Date: 14th August 2018

Our ref: 14677/SSL/SW/15983452v1

Representations in relation to application (ref. AL/20/18/OUT) for outline planning permission for up to 27 dwellings at Bridge Cottage & The Old Cottage Lidsey Road, Lidsey, PO22 9PH

Rev B 10/07/18 House Footprints amended.

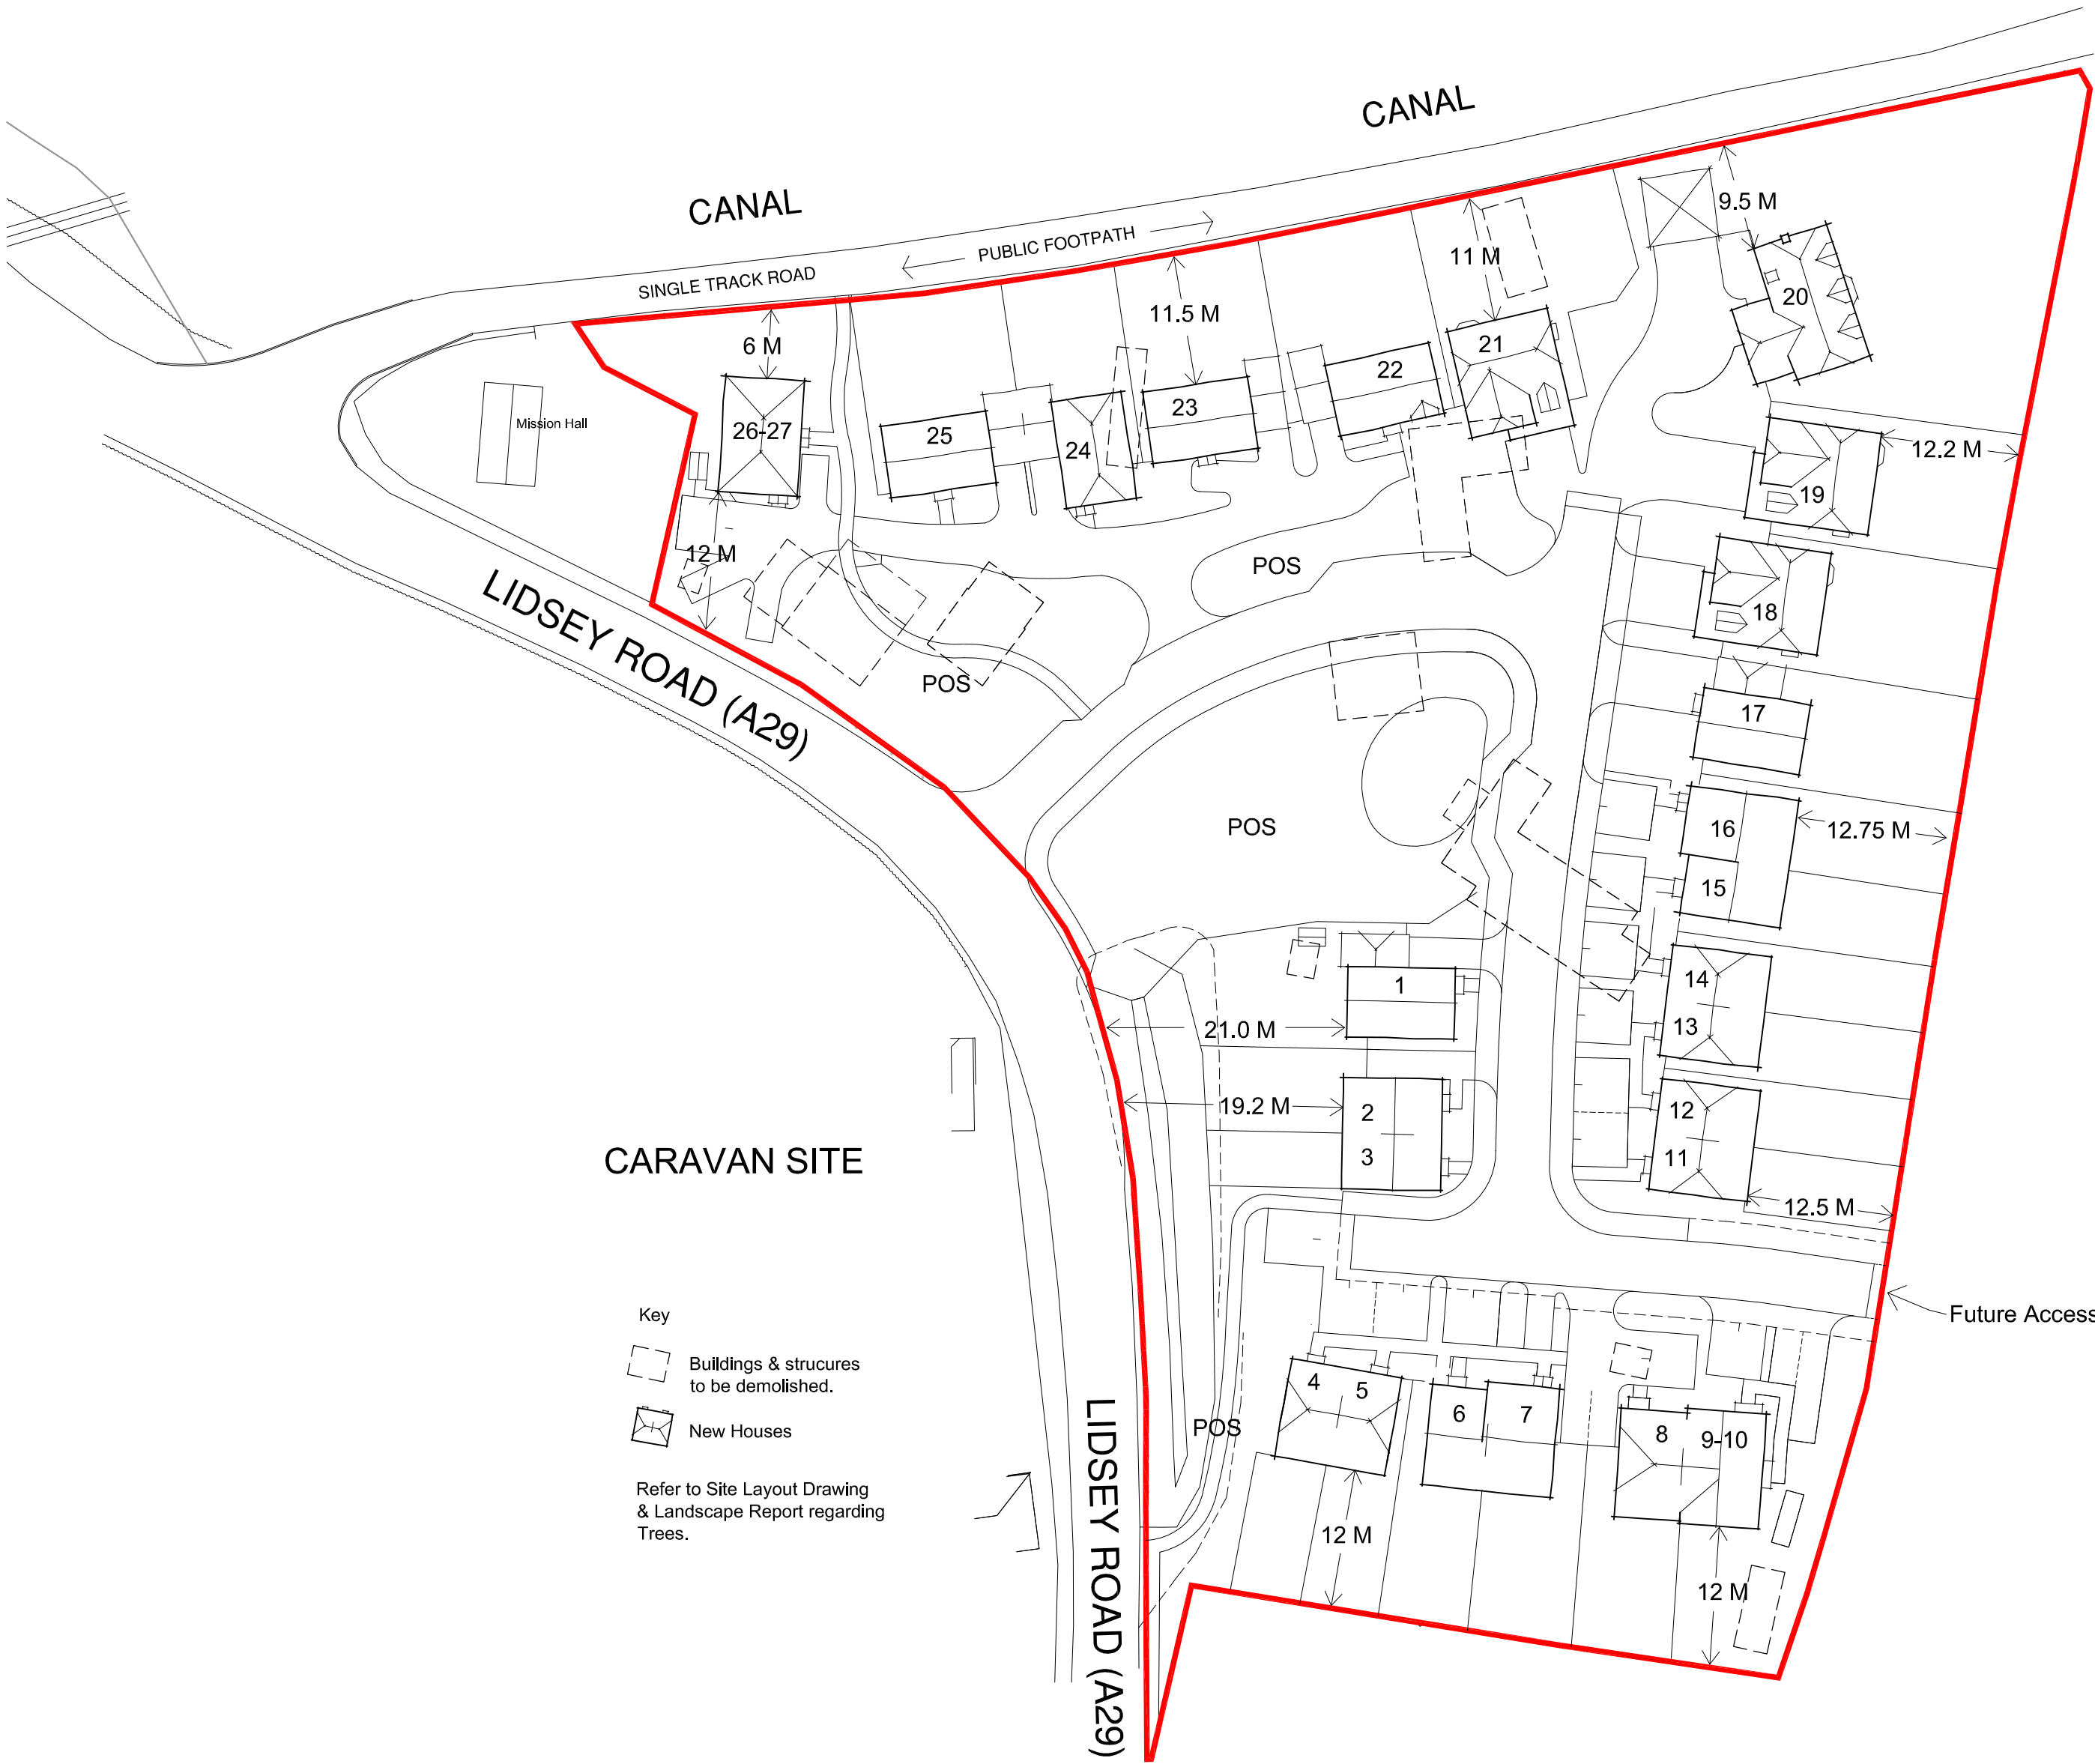
Firstly, it is important that every opportunity is taken to ensure that the proposed development successfully integrates with the wider BEW site as required by Policy H SP2c SD5. We welcome the secondary access road that is now proposed but note that this road should be made wider to 5.5m width to reflect 'Manual for Streets' as referred to in the West Sussex Design Guide; in addition, the provision of 2.0m wide footways on both sides of the road should be included in the proposed design to promote pedestrian linkages between the two sites.

Pell Frischmann (Transport Consultants) have reviewed the amended plans and also consider that the footway provision both within the site and to the bus stop is not adequate, as the footways do not extend to the site boundary. Where the footway is shown as 'Footpath towards the bus stop to the south' it does not provide a continuous access to the bus stop, as there is no footway on Lidsey Road south of the redline of the application site. Accordingly, the provision of footpaths should be reconsidered before the application can proceed.
